WELWYN HATFIELD COUNCIL – DEVELOPMENT CONTROL
DELEGATED REPORT

APPLICATION No:	S6/2008/1879/FP
------------------------	------------------------

The proposal is to convert the existing storeroom and function room to a restaurant to be used in conjunction with the existing Public House.

Drawing PROPOSED
 Plans & Elevations

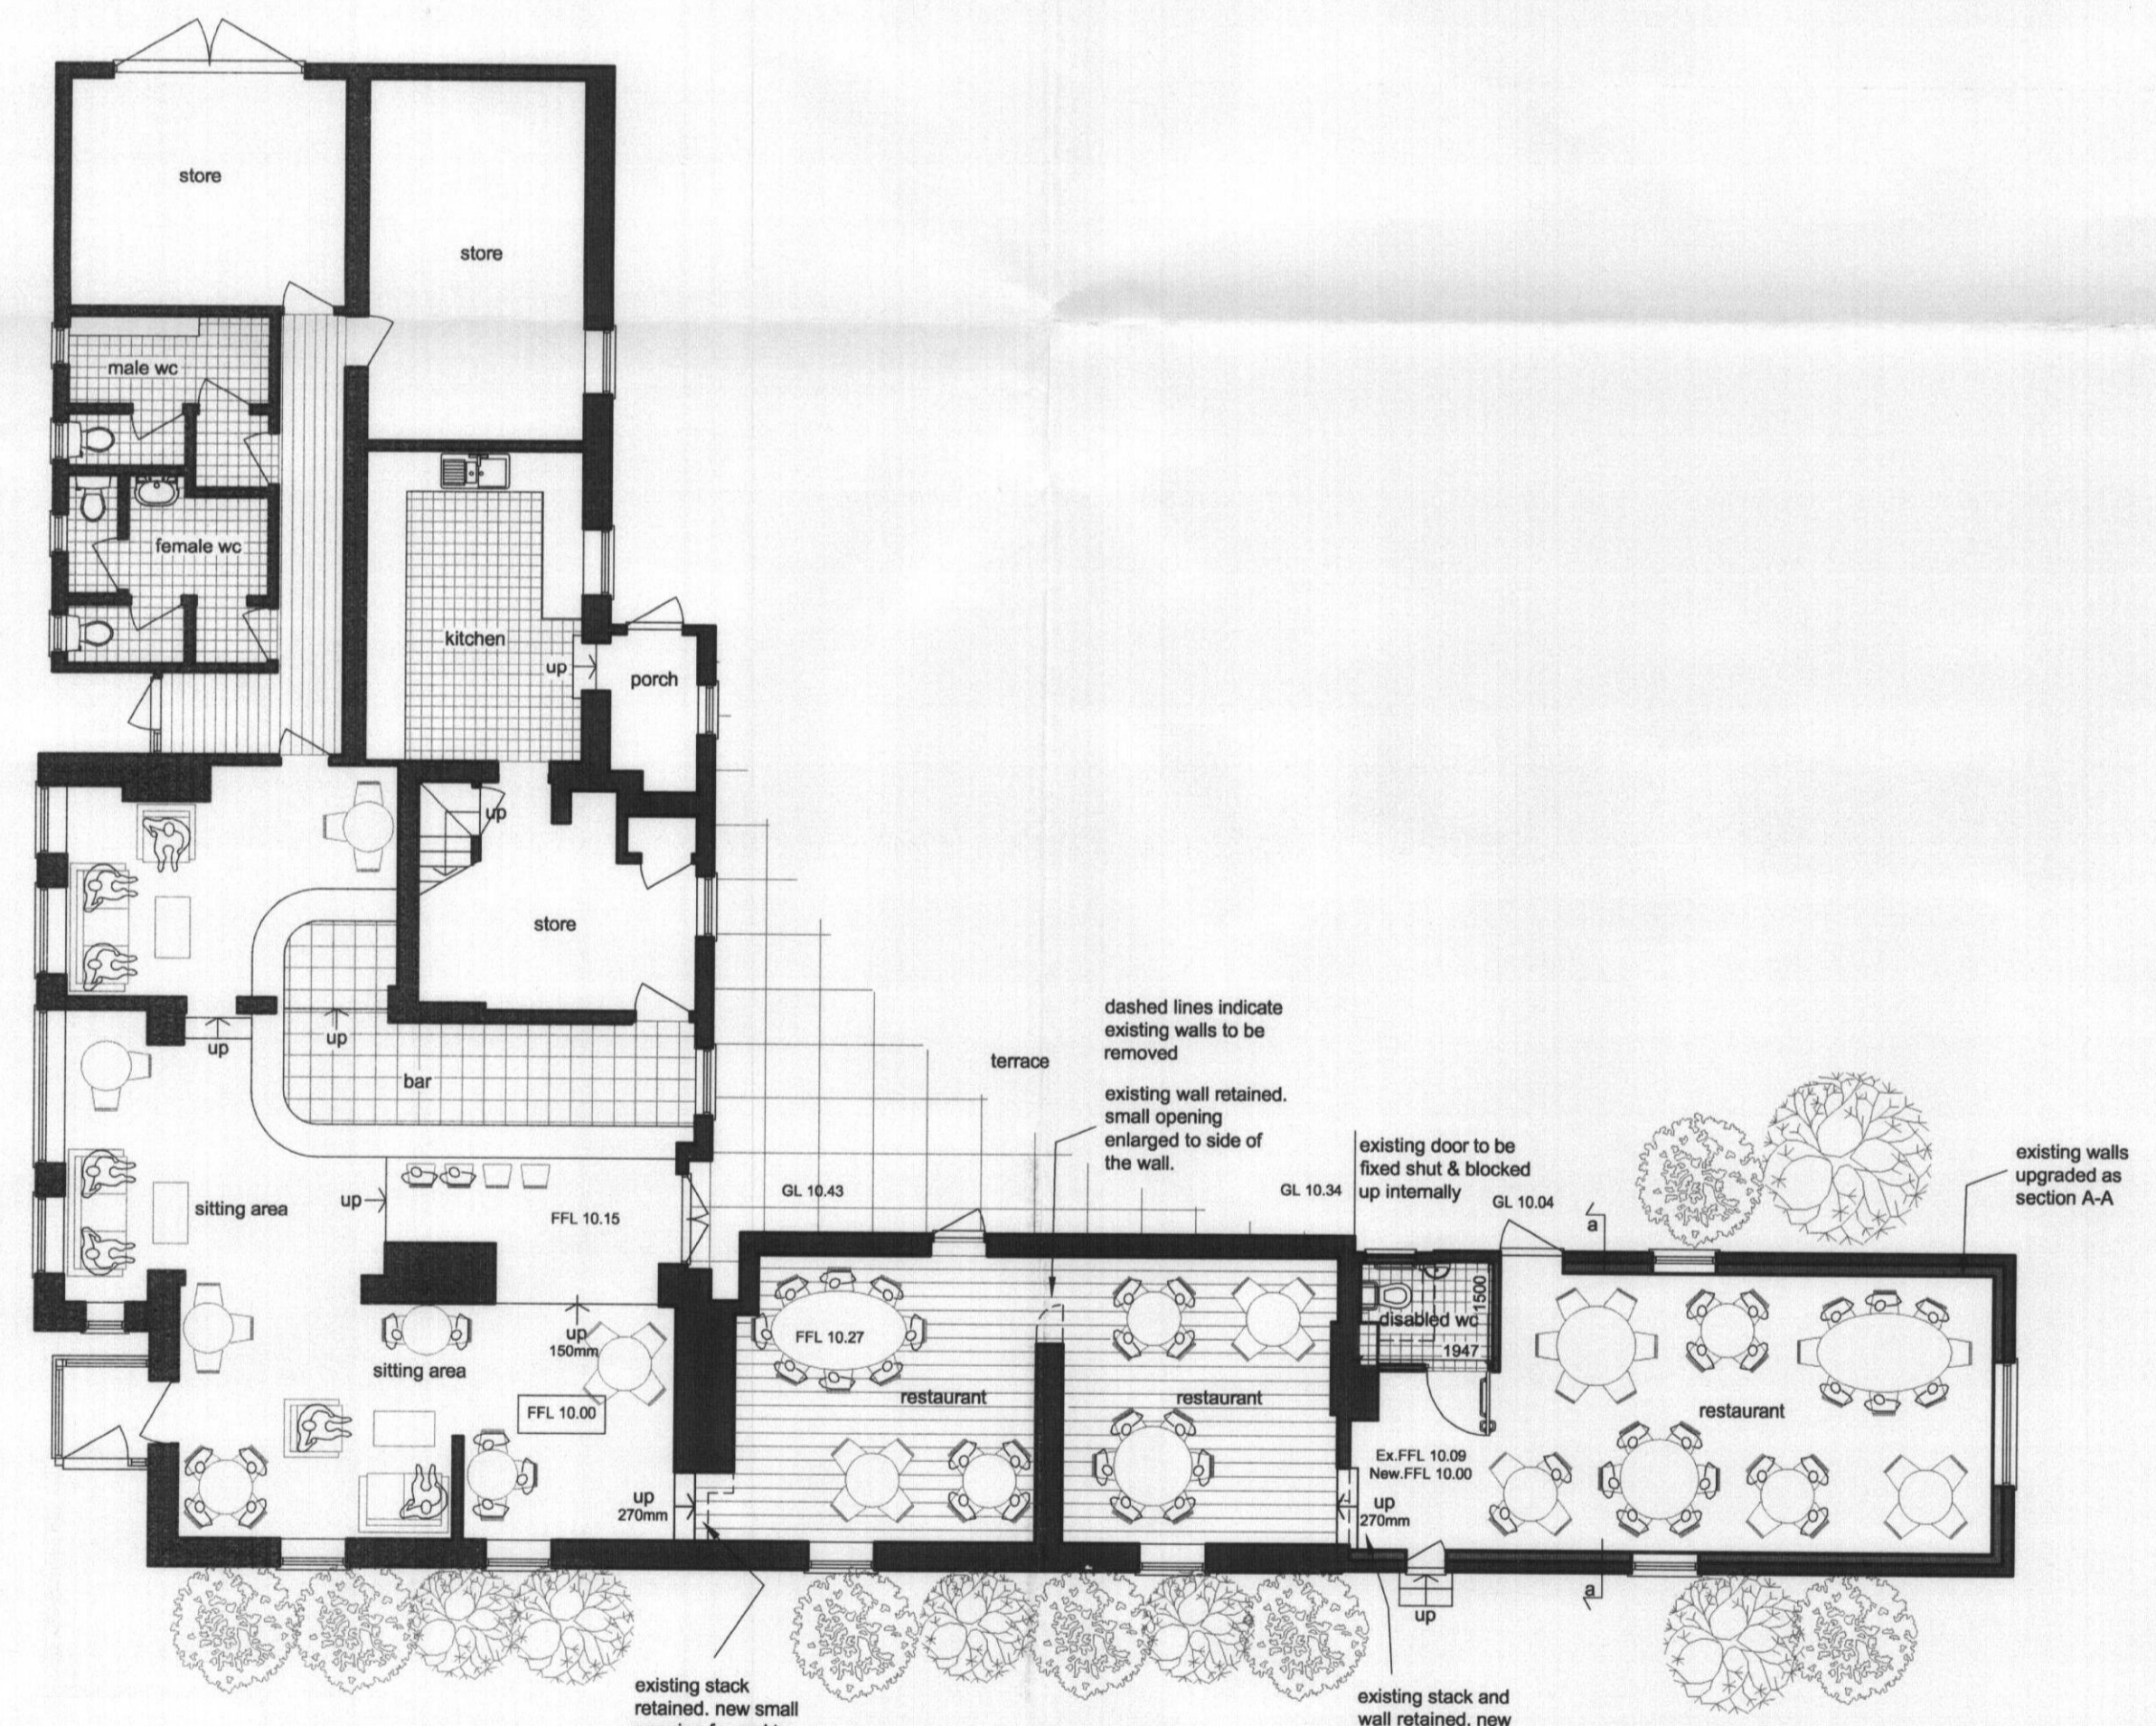
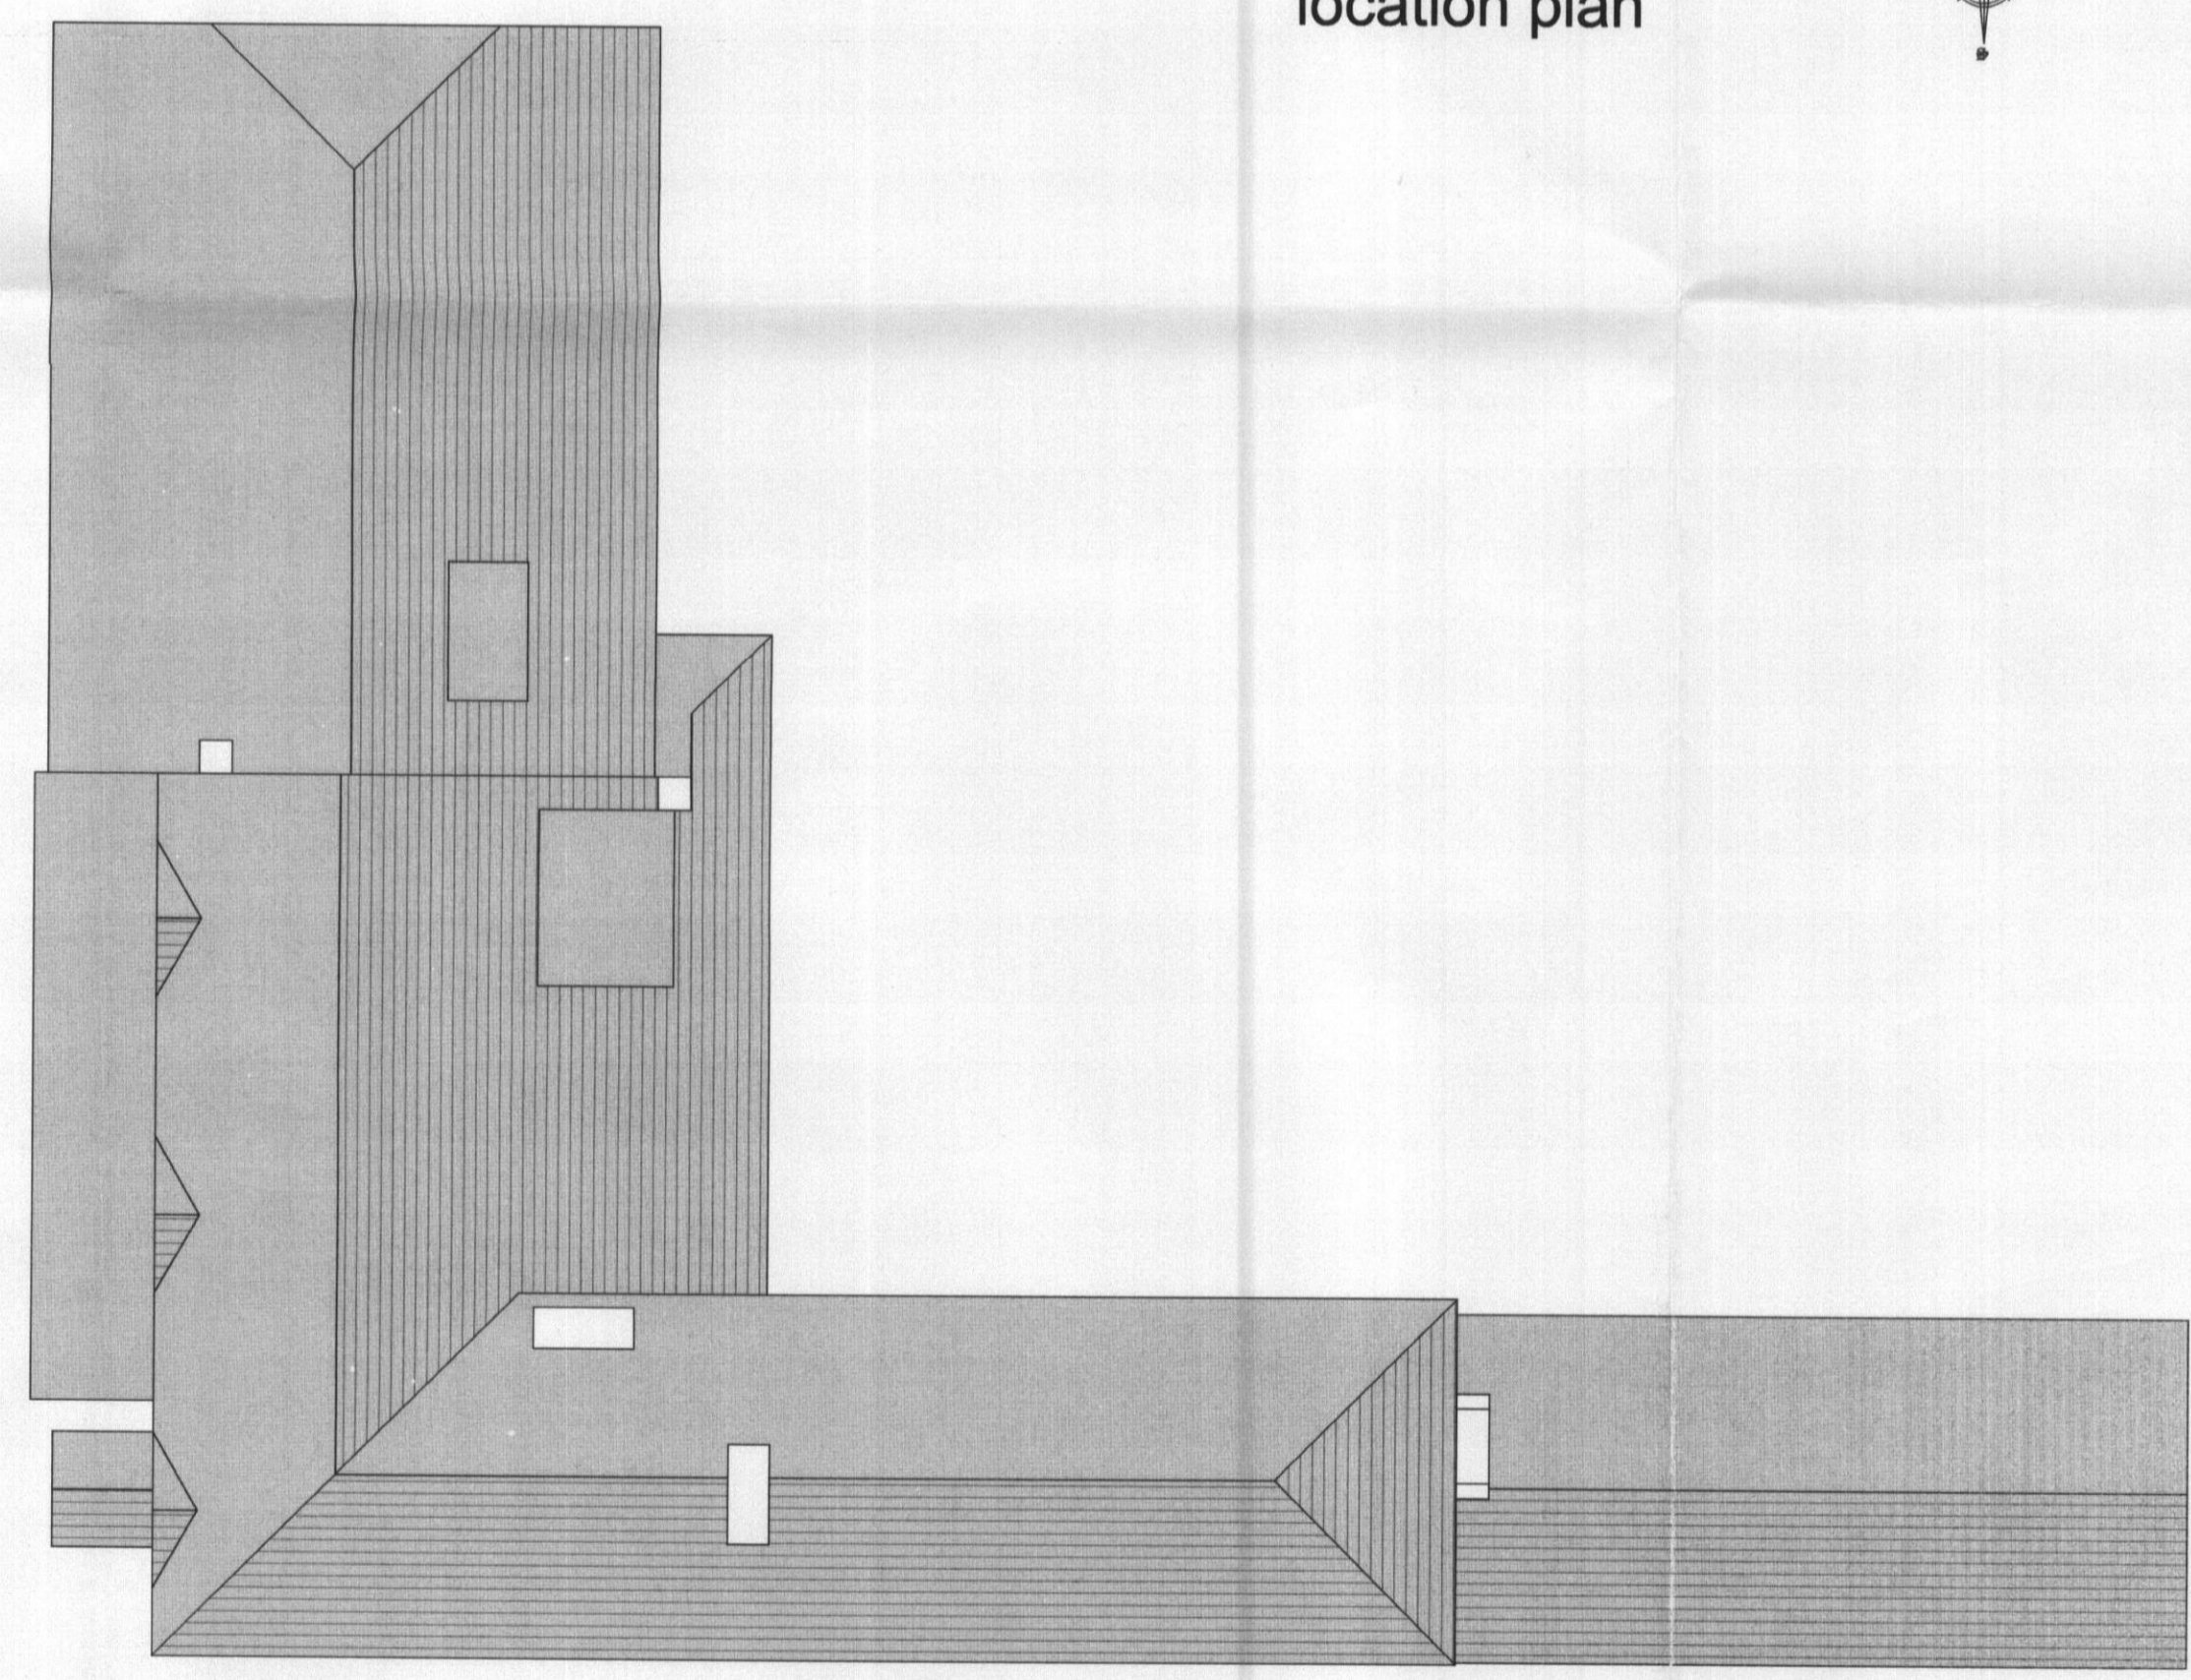
It is surprising that no link currently exists between the main part of the building and the two storey wing and possibly this may have been closed off in the past. Following a site meeting further detailed drawings have been submitted showing the opening located in a section of the wall which is thinner than the rest as this would result in less intrusion to the brickwork and could be the location of an earlier door.

In regards to the widening of an existing gap, this amendment was again considered to have less impact than the earlier proposal of creating a completely new door opening. Finally the size of the opening proposed into the single storey building has been reduced. Further sectional drawings have been produced to show some of the features of the building.

The applicants have submitted revised drawings showing the new openings to be as small as possible. Taking all these factors into account, and subject to more detailed drawings and information required by a planning condition below, it is considered the proposal will comply with PPG15
